Our Reference: SYD12/00262
Your Reference: MP11_0092
Contact: Xi Lin
Telephone 8849-2906

**EXHIBITION OF ENVIRONMENTAL ASSESSMENT FOR
SYDNEY CITY GRID STAGE 2A (II)**

I refer to your letter dated 24 February 2012 (Departments Reference: MP11_0092) with regard to the abovementioned Environmental Assessment (EA), which was referred to the Roads and Maritime Services (RMS) for comment.

DRAWING Stratum Plan - Level 03 Parking

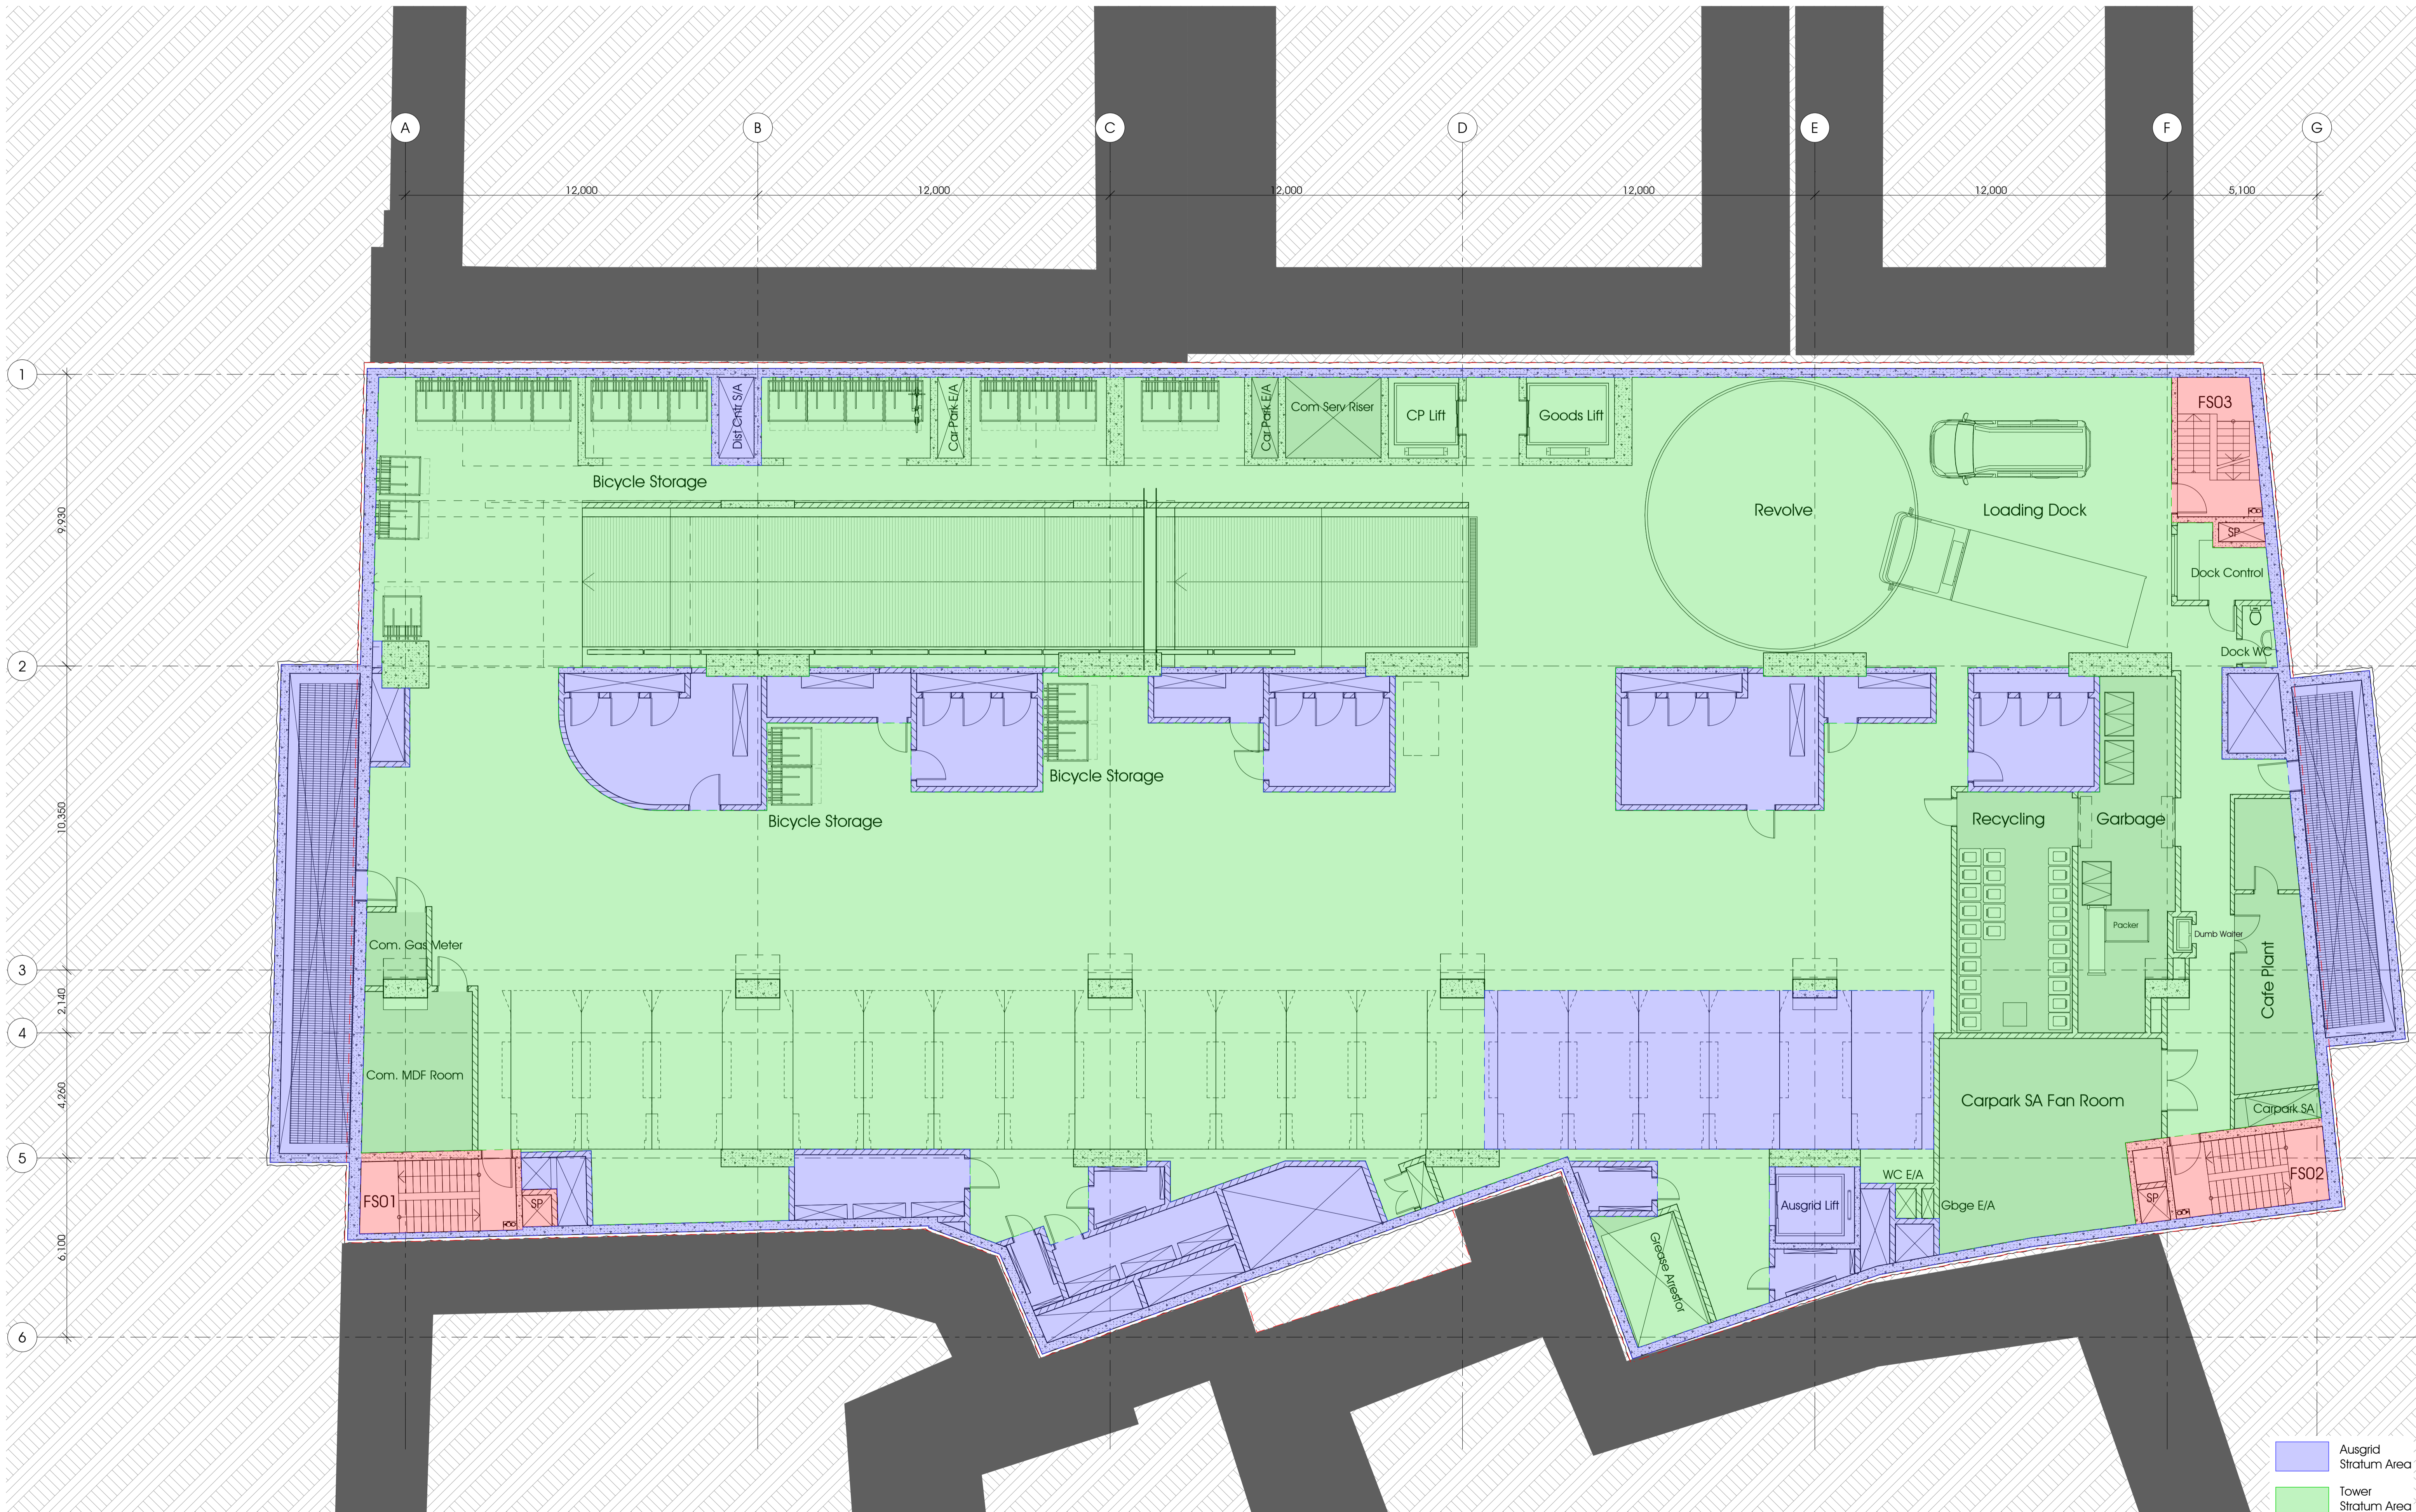
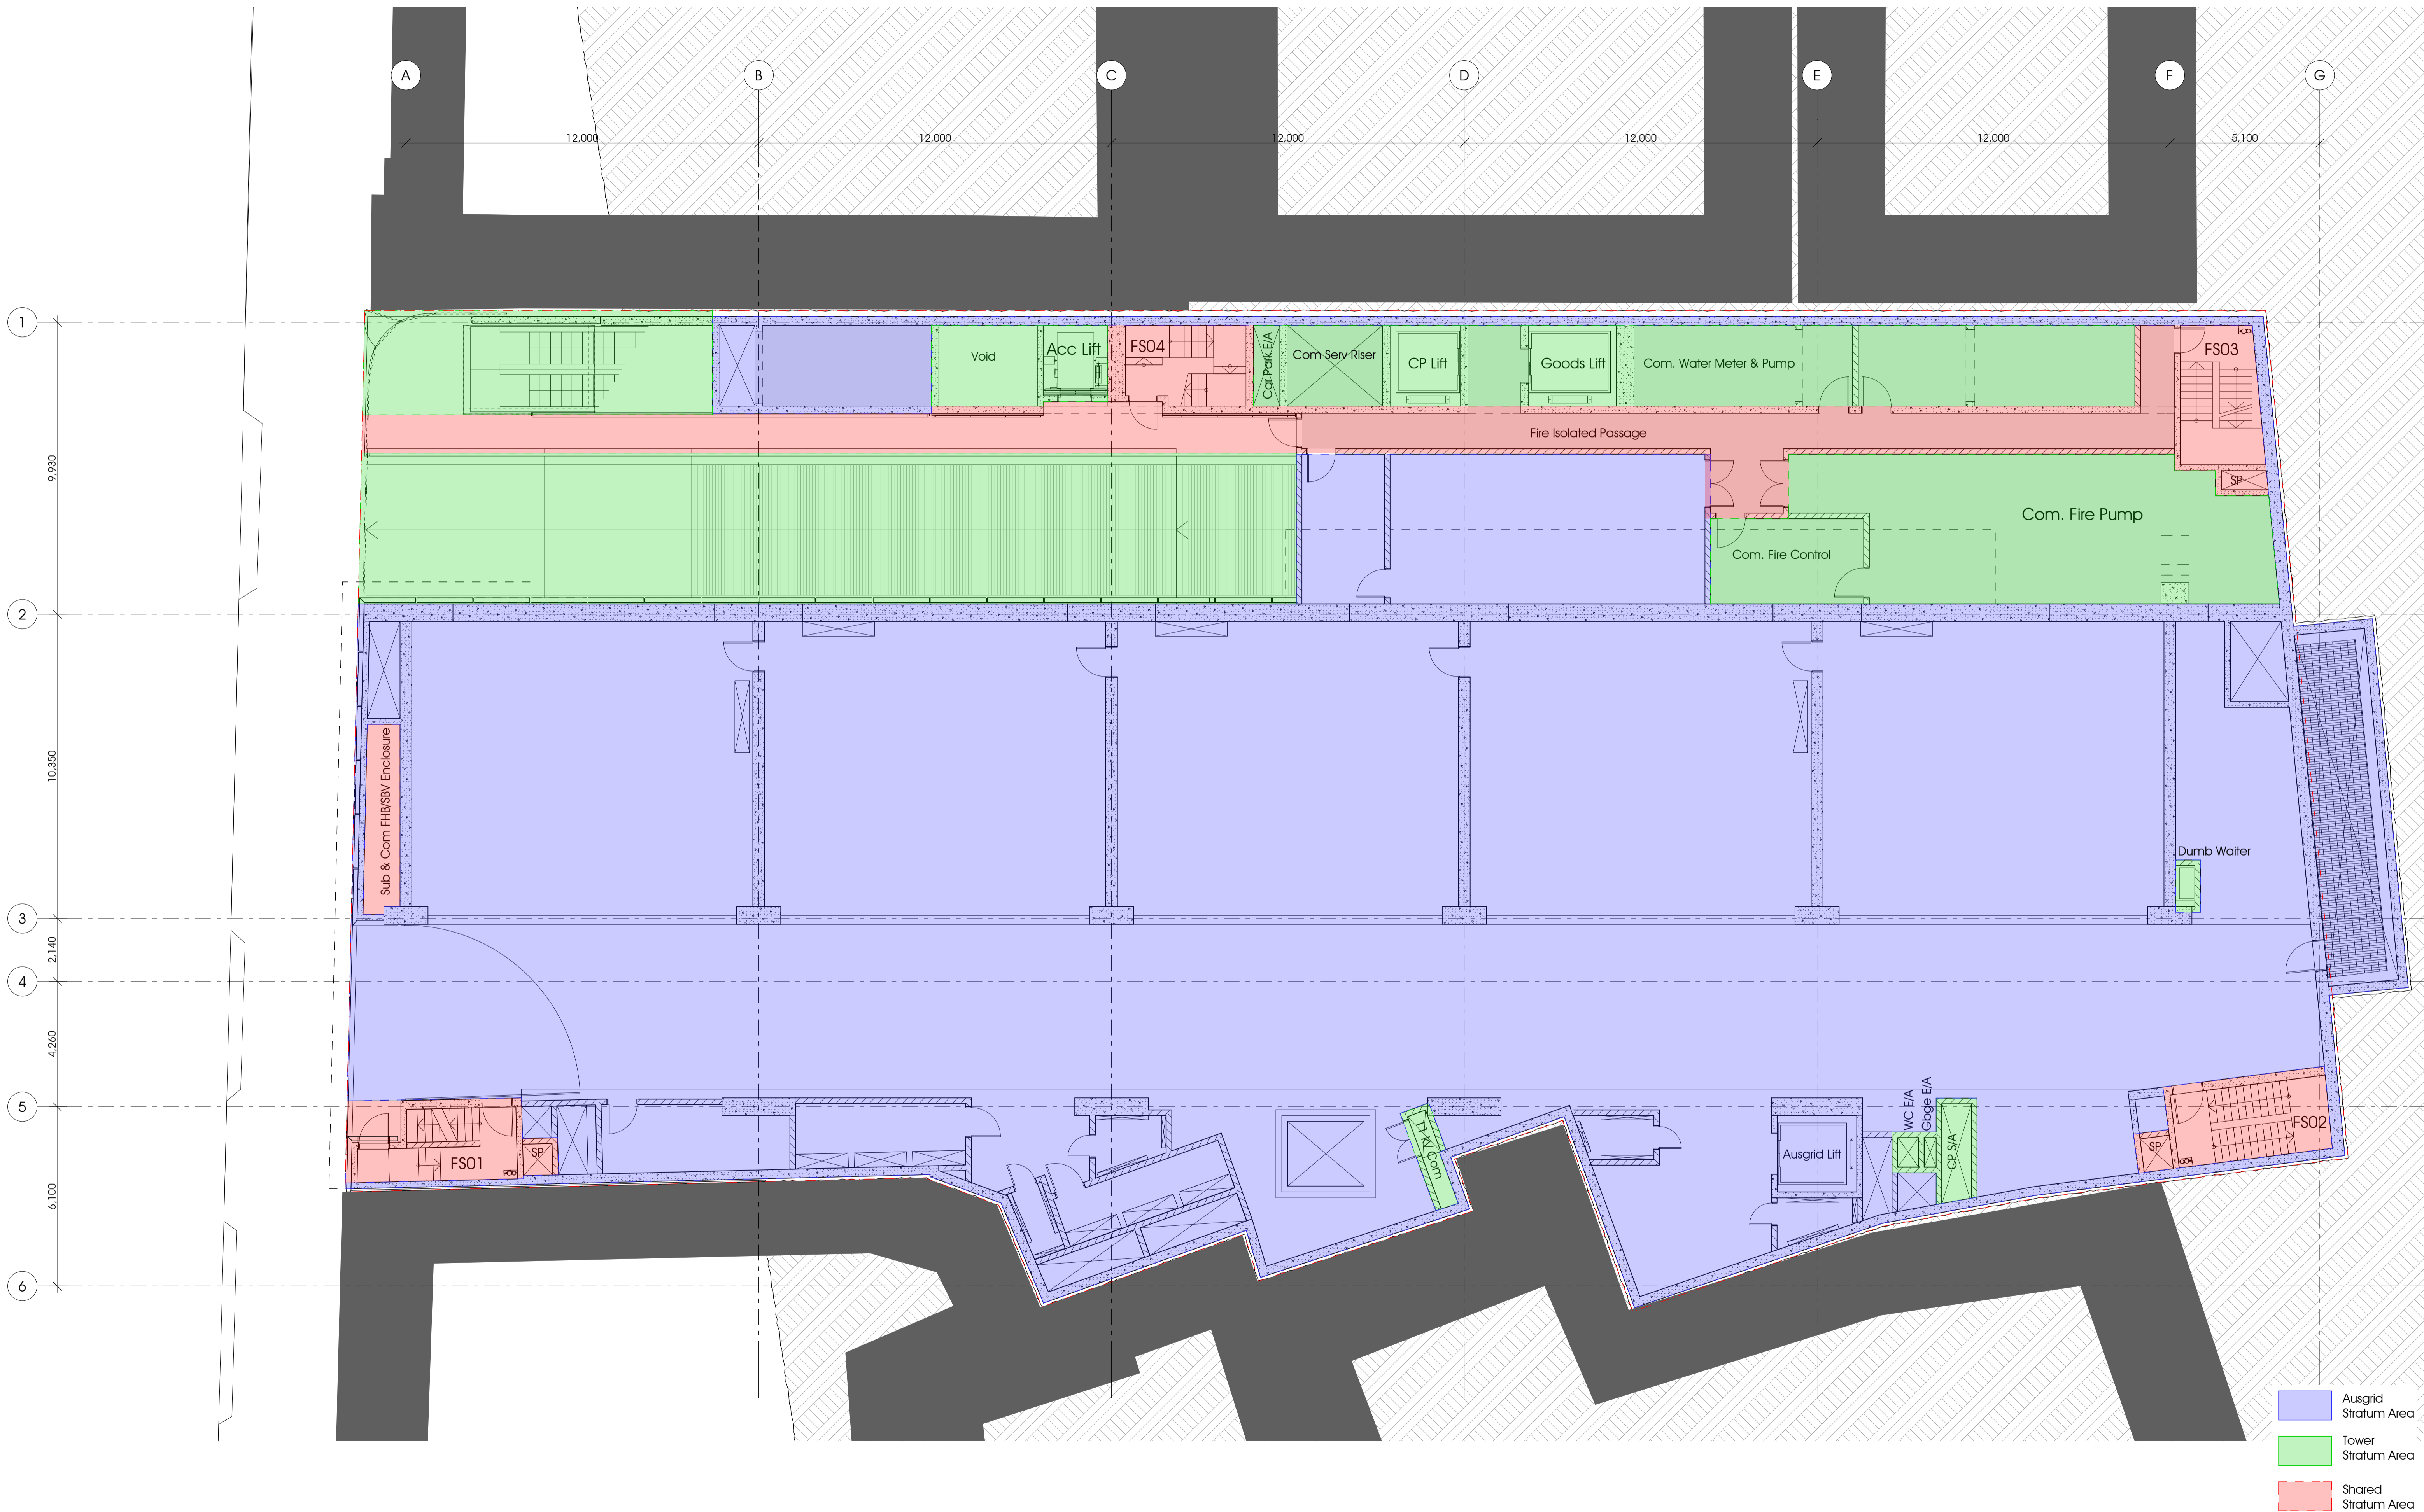
1. The layout of the proposed car parking areas, loading docks and access driveway associated with the subject development (including, grades, turn paths, lifts, sight distance requirements, aisle widths and parking bay dimensions) should be in accordance with AS 2890.1- 2004 and AS 2890.2 – 2002 for heavy vehicle usage.
